**Our Ref: EG/69/13/
Your Ref:**

Application for Planning Permission for Works or Extension to a Dwelling

Development Garden shed with log store
Location 1 Abercorn Walk Old Rectory Drive Eastergate

Scale 1:500

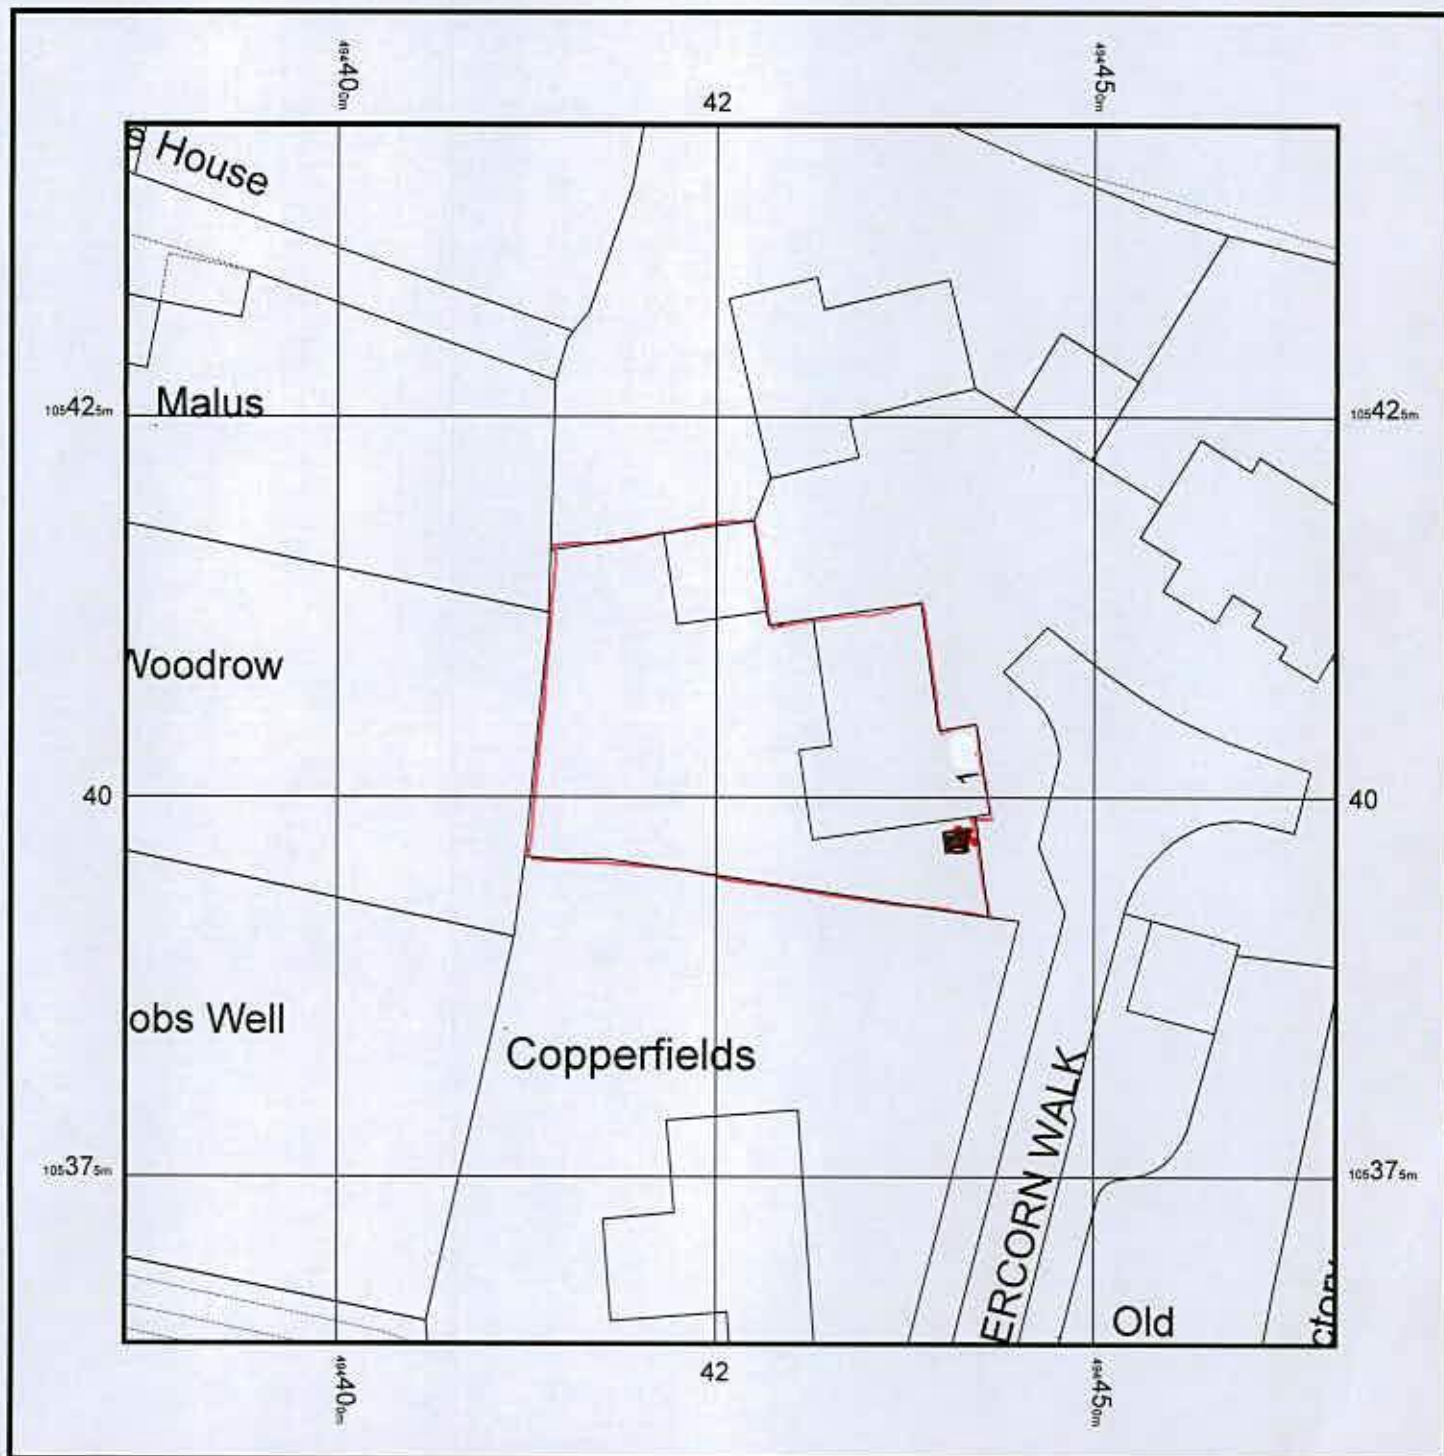
Please provide an amended block plan to show measurements to each boundary from the proposal (in metric)
